From: Amanda Scholes on behalf of Planning.Responses
Sent: 26 September 2018 09:04
To: Planning Scanning
Subject: FW: AB/36/18/PL - Blastreat / Greenhurst, Fitzalan Road, Arundel
Attachments: AHA objection letter 09.09.18.pdf

From: Peter Tanner [REDACTED]
Sent: 25 September 2018 17:30
To: Anita Gardner
Cc: Simon McFarlane; Matt Turpin; Nick Watkins; Ziyad Thomas; Alex; Laurie Marlow
Subject: Re: AB/36/18/PL - Blastreat / Greenhurst, Fitzalan Road, Arundel

Re: 46 retirement Flats at Blastreat and Greenhurst , 14 Fitzalan Rd Arundel.

Block Plan
Scale 1:500

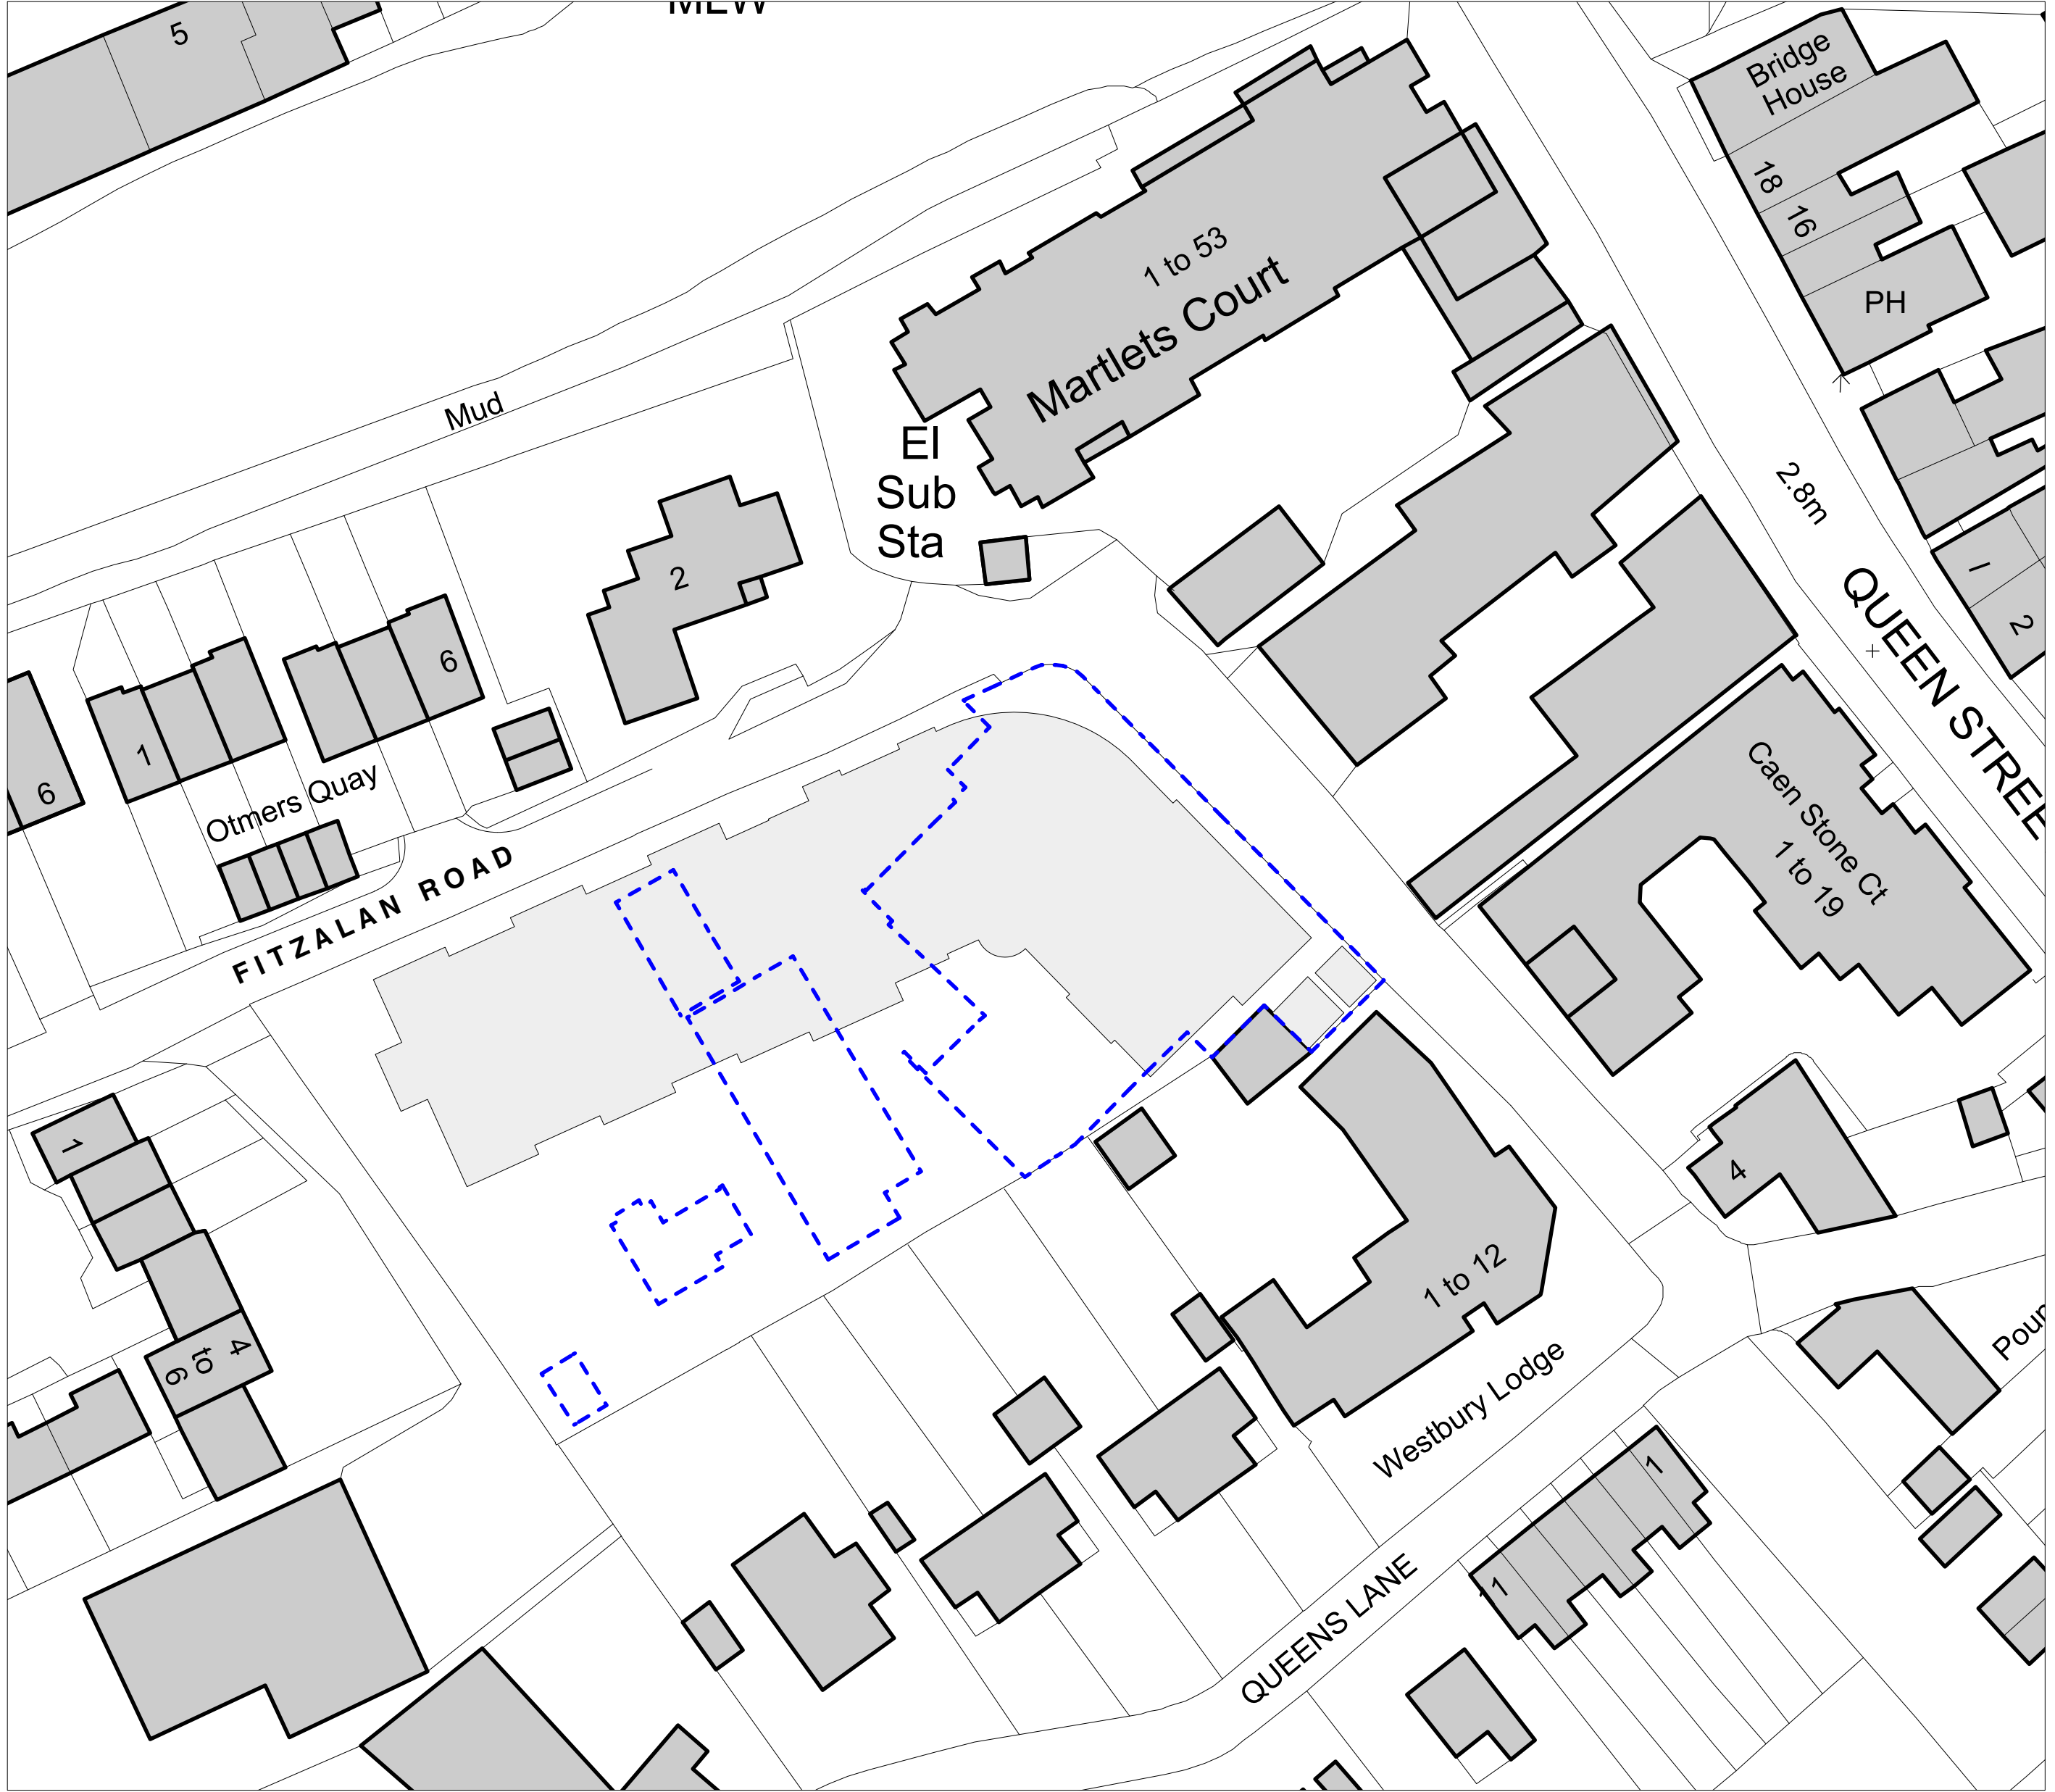
23. Please can the applicant confirm precise width of staircase, driveway and verge adjoining the elevation nearest the access. It is currently unclear how each can fit in a width of about 5.8m. **This is potentially very material as it appears that the block cannot fit on the available land or the access road is below standard.**

24. Please can the applicant provide a visibility splay to left / West. **This is potentially very material as they appear below the standard.**
25. The main staircases around the buildings are not shown on the block plan, nor are the raised terraces. Both are structures that form part of the footprint of the building so should be shown in grey. **This is a material drafting error.**

26. We cannot see a turning head suitable for emergency service vehicles. **This is potentially very material.**
27. Please can the applicant label the grey structures next to Westbury Lodge.

28. Please can the applicant show the car ports on the block plan as distinct from open car parking spaces. Both are coloured the same, giving the incorrect impression of a large open car park when in fact a large percentage of it is covered in a vast car port.

23. The site layout conforms to the topographical survey. The access driveway is 6 metres wide in line with the front elevation and narrows to 4 metres opposite the entrance to the buggy store before widening out to between 5.8 metres and 7.5 metres adjacent to parking spaces 1 to 4. This arrangement provides satisfactory width for two vehicles to safely pass each other along the driveway with adequate forward visibility along this access in both directions. The drawing is not in error.

24. A Road Safety Audit has been carried out at the request of the Highway Authority and this will be submitted together with a drawing showing sight line visibility at the access junction satisfying the guidance in Manual for Streets.

25. It is not usual architectural convention to show steps and terraces within the grounds as part of the building footprint on the Block Plan. This is not an error. The relationship of steps and raised terraces to the building are clearly shown on the Site Plan drawing 1650-51A.

26. A turning head for deliveries and ambulances is shown between parking spaces 11 and 12 as shown on the Site Plan and is further illustrated in the tracking diagrams to appendix C of the submitted Transport Statement. Refuse vehicles will service the site from the road. The majority of existing properties on Fitzalan Road are similarly serviced from the road. There is sufficient width of access for fire appliances to enter the site although in reality it is likely that in the event of a fire a fire appliance would park on Fitzalan Road, as would be the case for existing properties along Fitzalan Road.

27. These buildings are labelled on the site plan.

28. The car port is clearly indicated on the Site Plan. This can be shown on the Block Plan if requested by the LPA.

Reveal Elevation (South West)
Fronting Fitzalan Road

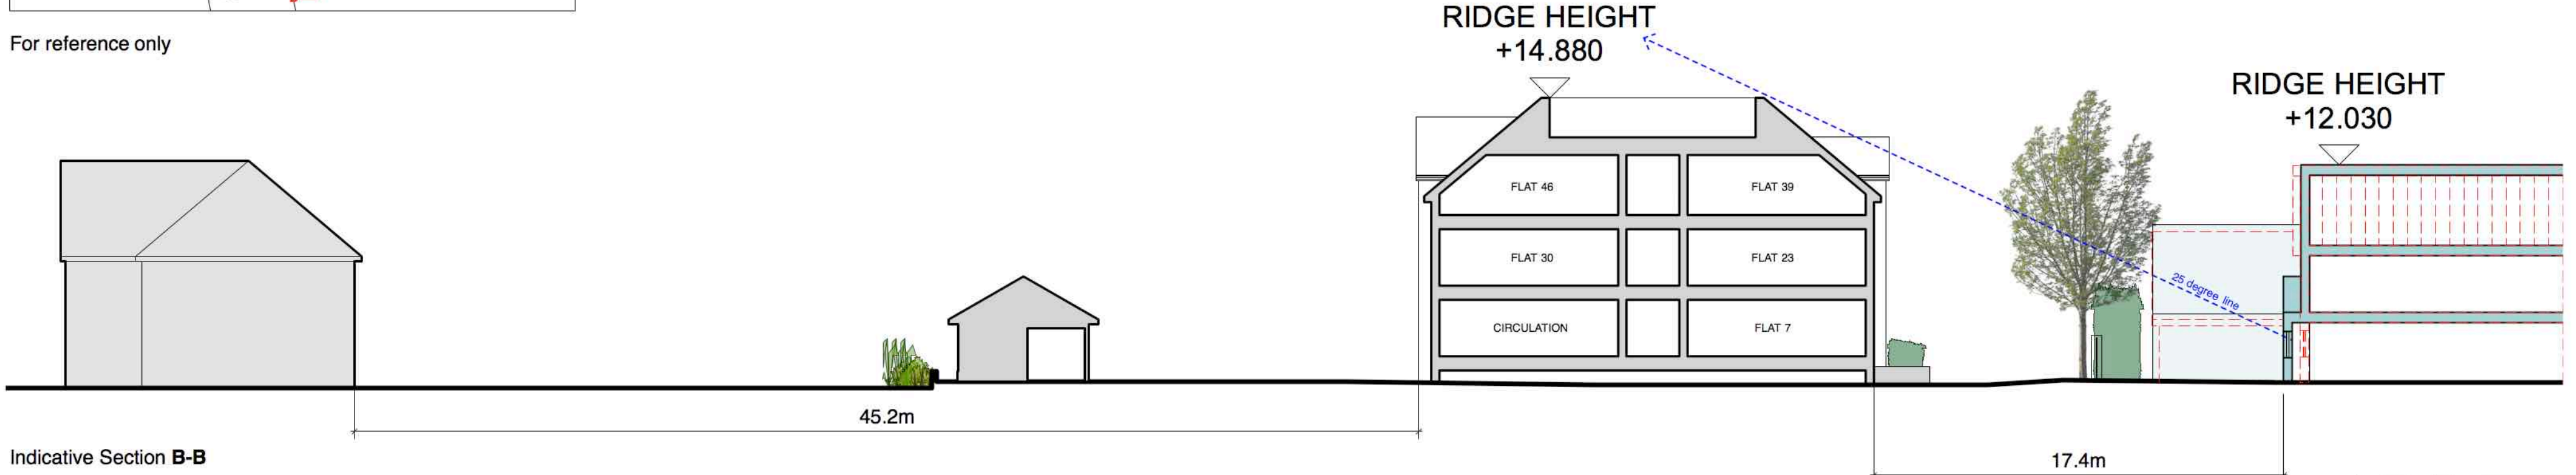
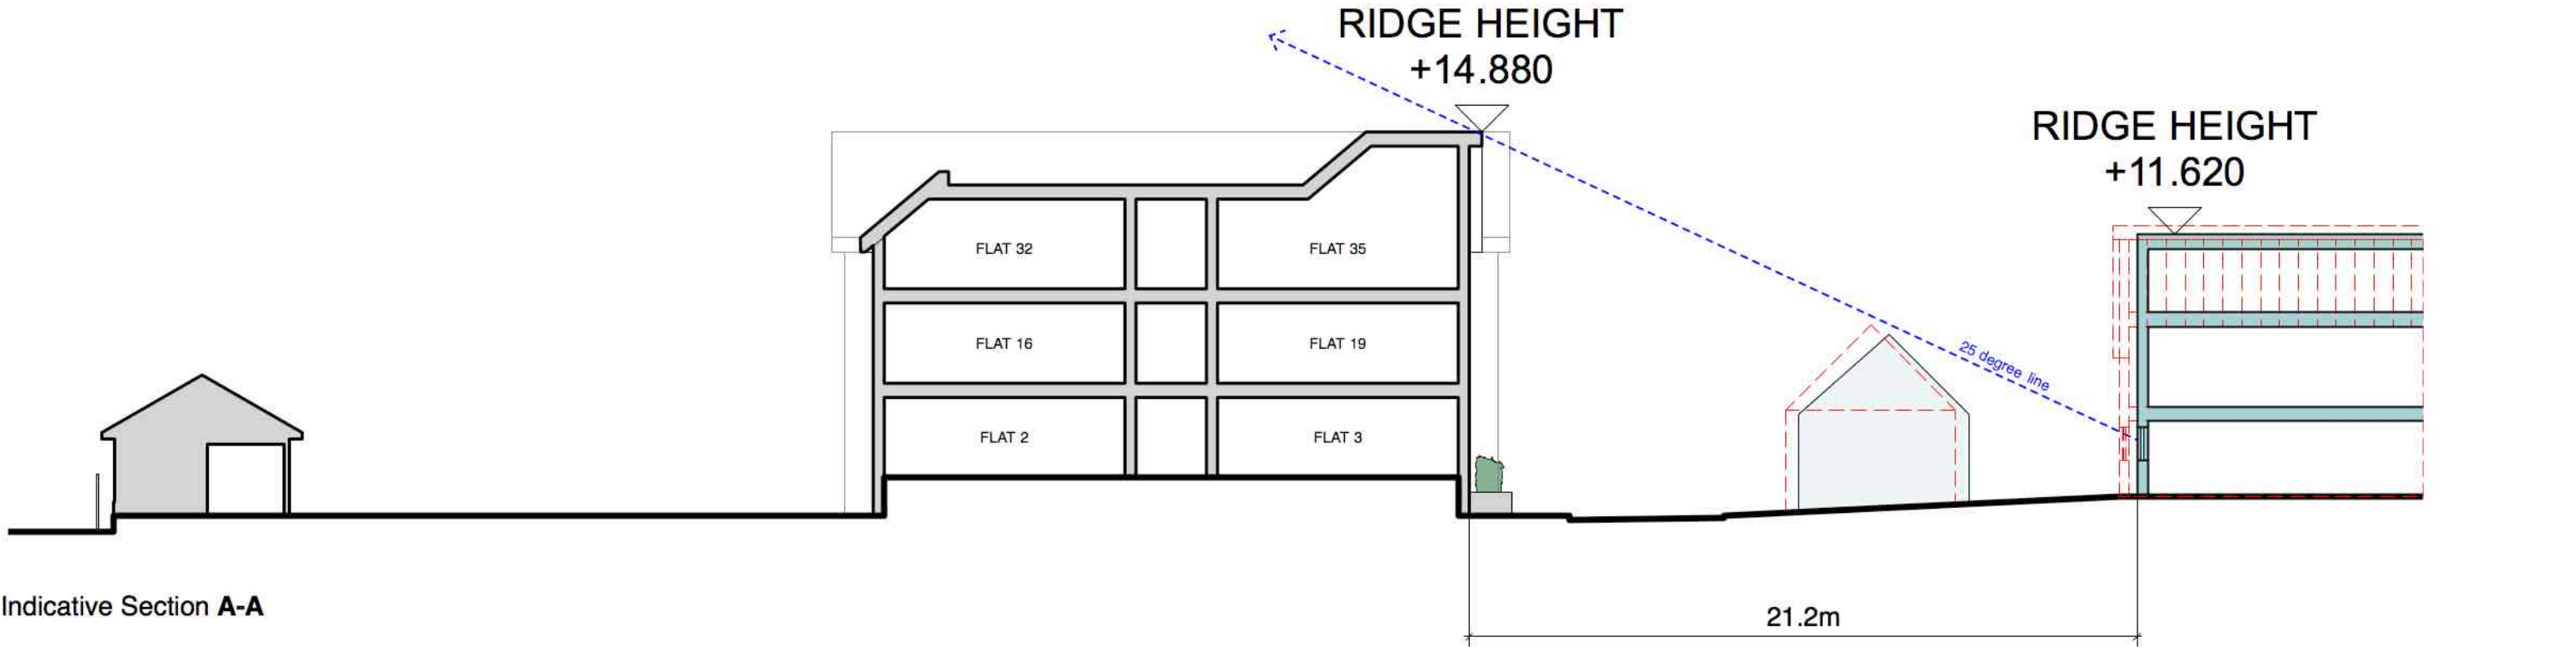
18. It is important to note that none of the plans clearly show the relationship between the balconies and windows of the most southerly part of the proposed block adjoining Westbury Lodge and the rear gardens of Queens Lane. This section of the building is described as the “Reveal Elevation” on the applicant’s drawings. It shows 3 balconies and 7 windows facing at 45 degrees towards the rear gardens of Queens Lane. This means a person standing on the proposed first floor balconies could see into the rear gardens only around 6m away. This is impossible to determine on any of the plans and is such a gross breach of overlooking and privacy that a clear plan showing the overlooking must be provided.

20. The reveal elevation also misleadingly shows the electricity sub-station as a detached single story building with greenery all around it. By contrast, it is attached to a garage belonging to Westbury Lodge. **This is material**. This building incorrectly gives the impression of being the side elevation of one of the car ports. It is not and this should be annotated and clarified.

18. The nearest balcony is 6.2m from the fence of the parking court of Westbury Lodge and 7.9m to the rear corner of the neighbouring rear garden of the nearest Queen Lane property. Notwithstanding, the line of sight from the proposed balconies will be curtailed by the existing outbuildings to the rear of Westbury Lodge and by the proposed pitched roof carport barn. This, together with the distance of separation and oblique view from these balconies is such that there will be no harmful overlooking or loss of privacy. This can be clearly deduced from the submitted drawings.

20. The Ground Source Heat Pump building (notated GSHP on the drawing) is adjacent to the outbuilding within the grounds of Westbury Lodge. The 'Reveal' elevation shows the free standing substation building between the proposed building and Westbury Lodge. This can be noted if required.
